NATIONAL PARK SERVICE
Petroglyph National Monument
6001 Unser Blvd NW
Albuquerque, New Mexico 87120

Re: Project #: **PR-2025-020092**

Application #: **MAJOR_PLT-2025-00016 – MAJOR PRELIMINARY PLAT**

DHO Major Subdivision Action; Unassigned Addresses 99999 Valiente NW; Property Owner
“Volcano Cliffs Inc & Group I U26 LLC RM 115”

Plat for
Lots 1A-1-A, 1A-1-B, 4A-1-A, and
4A-1-B, Block 3, Volcano Cliffs
Subdivision, Unit 26

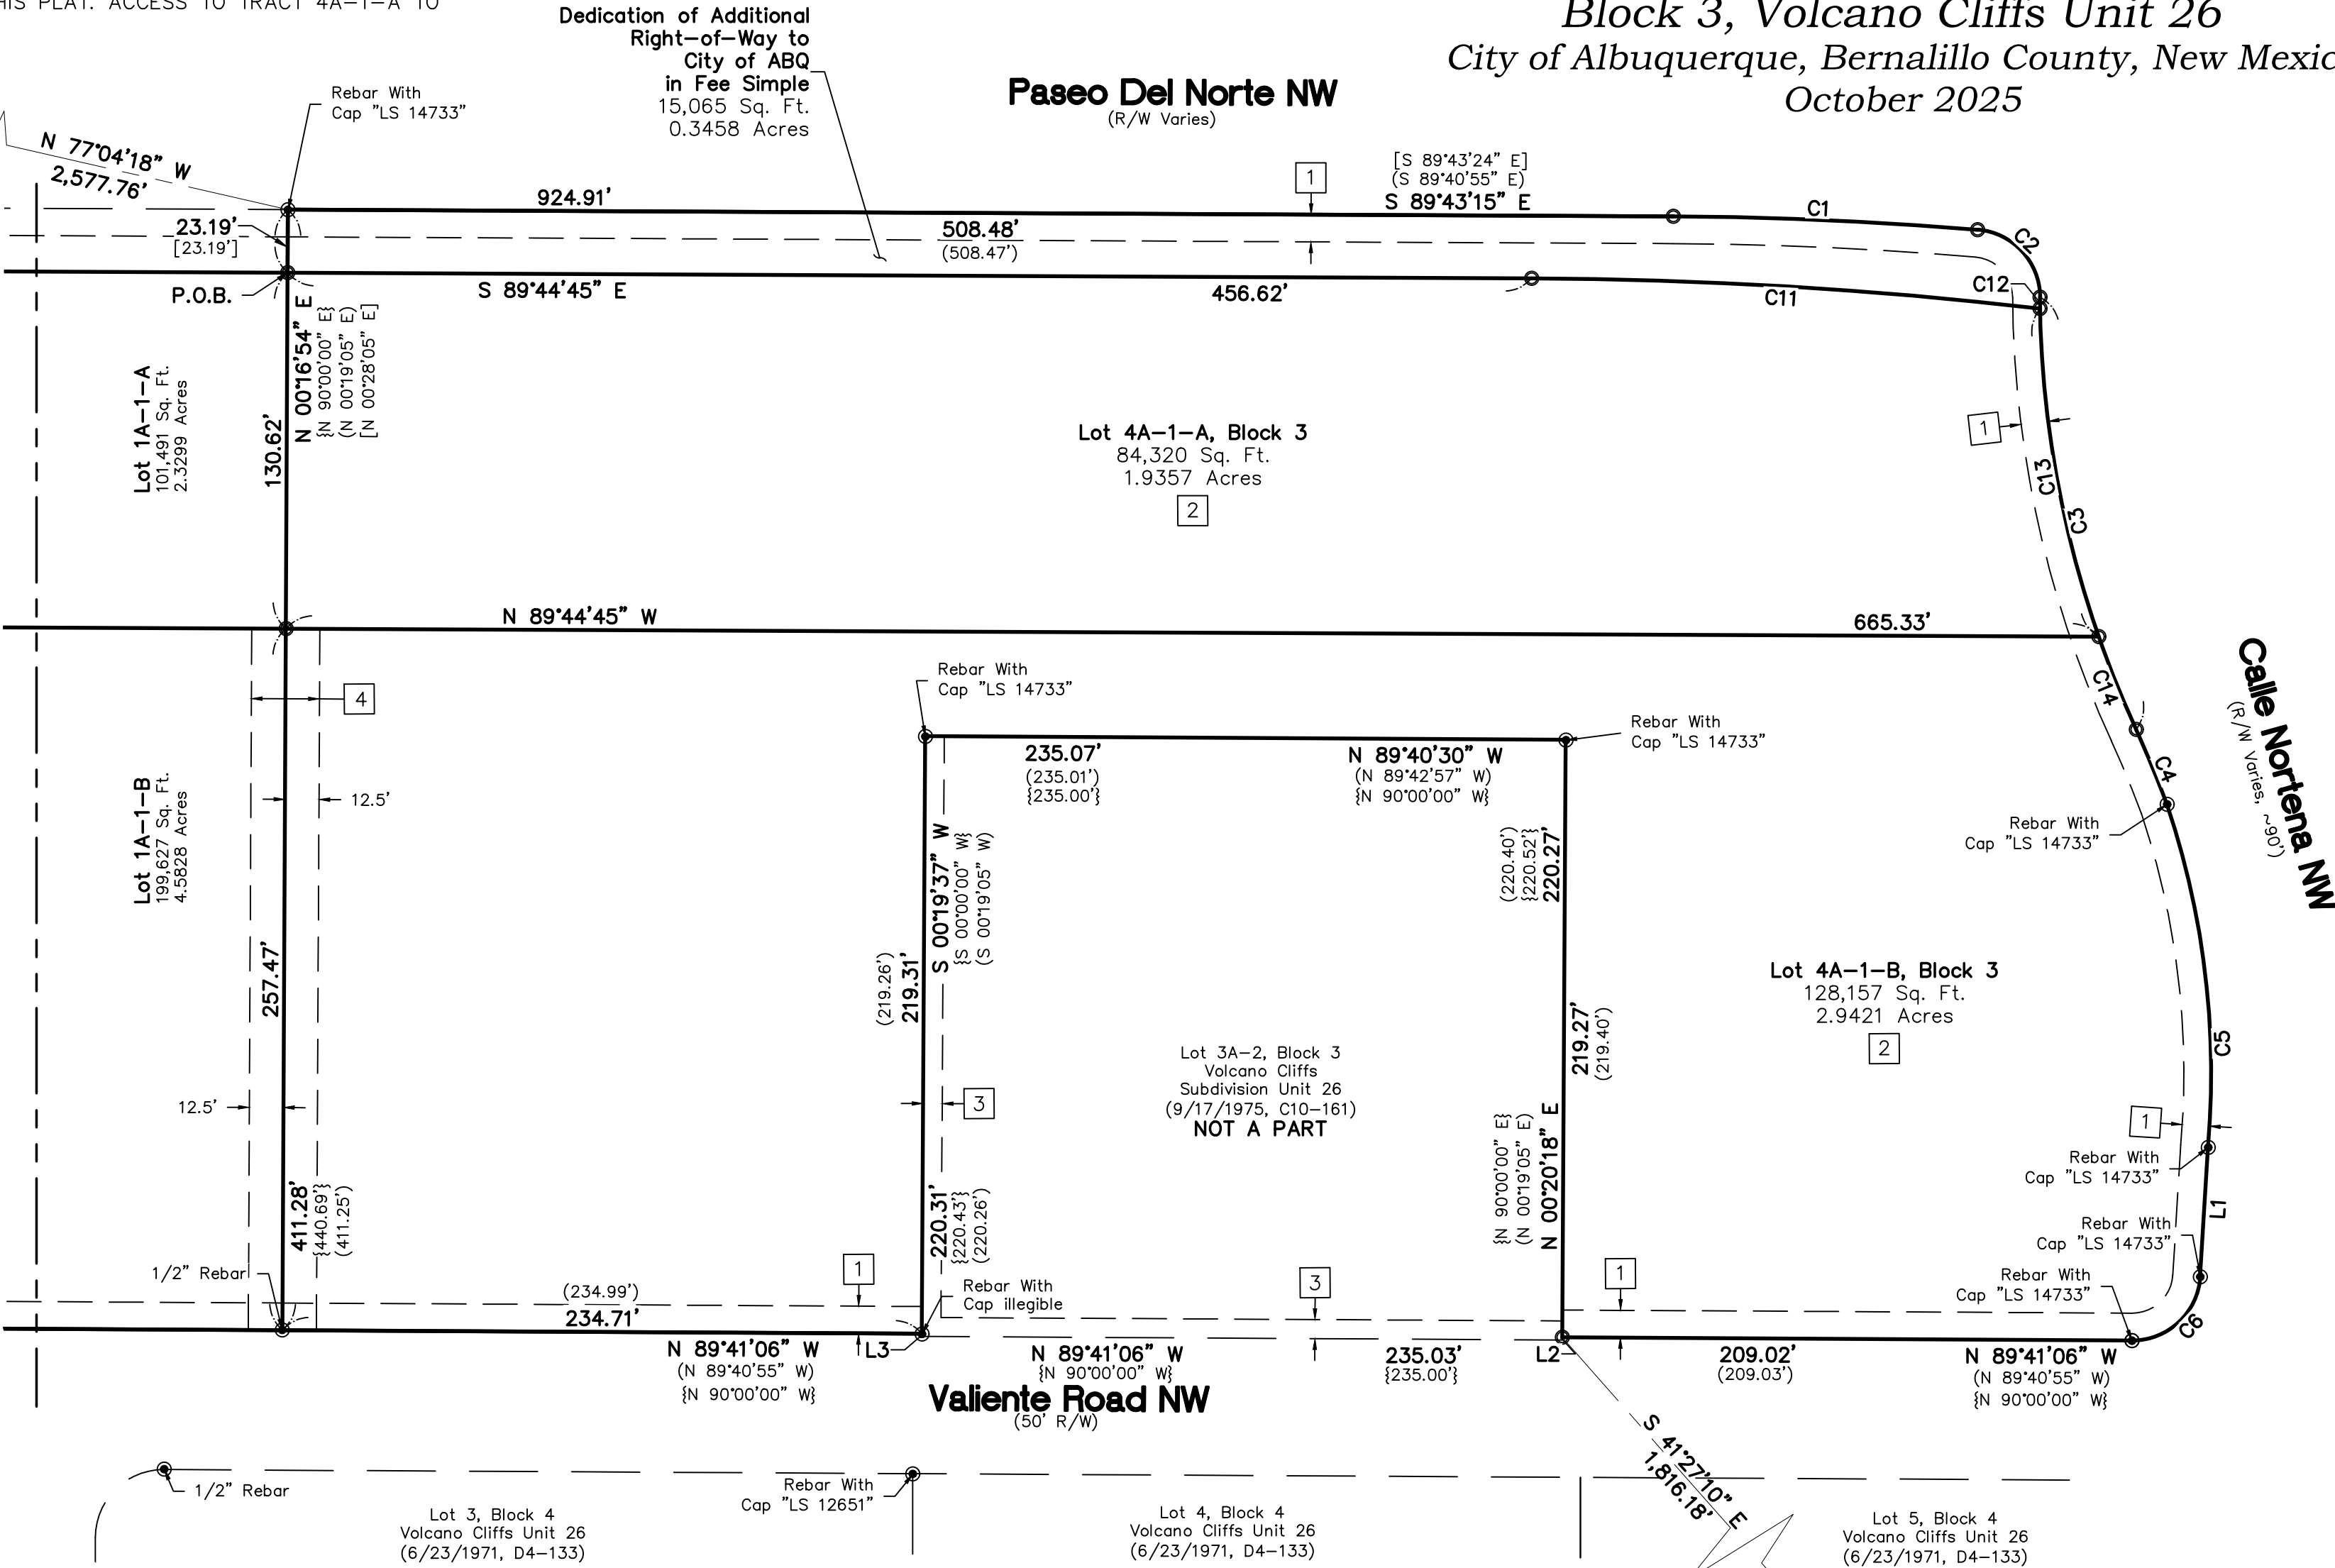
The National Park Service (NPS) opposes the referenced application that would result in the subdivision of property on the Southeast corner of Paseo and Kimmick into four tracts. It appears this project would affect the applicability of the VPO 2 – Northwest Mesa Escarpment View Protection Overlay Zone and allow for increased building heights in the existing VPO-2 Height Restrictions Sub-area.

While no development project or site plan is being proposed at this stage, it appears that if the area was subdivided, the requirements of VPO-2 would not extend into the newly divided parcels.

We could support the subdivision of the parcel (preliminary plat) if the protections of VPO-2 are imposed on the new parcels. Also, we question the process to approve this proposal. It's our understanding that the IDO requires the review and approval by the Environmental Planning Commission to allow for the subdivision of the parcels, including a sensitive lands analysis and review of a site plan.

Please uphold the IDO as written, continue to provide for the protection of Petroglyph National Monument by keeping the protection of the VPO-2 on the parcels if the subdivision (preliminary plat) is approved, and help us continue to protect the values and cultural resources of Petroglyph National Monument.
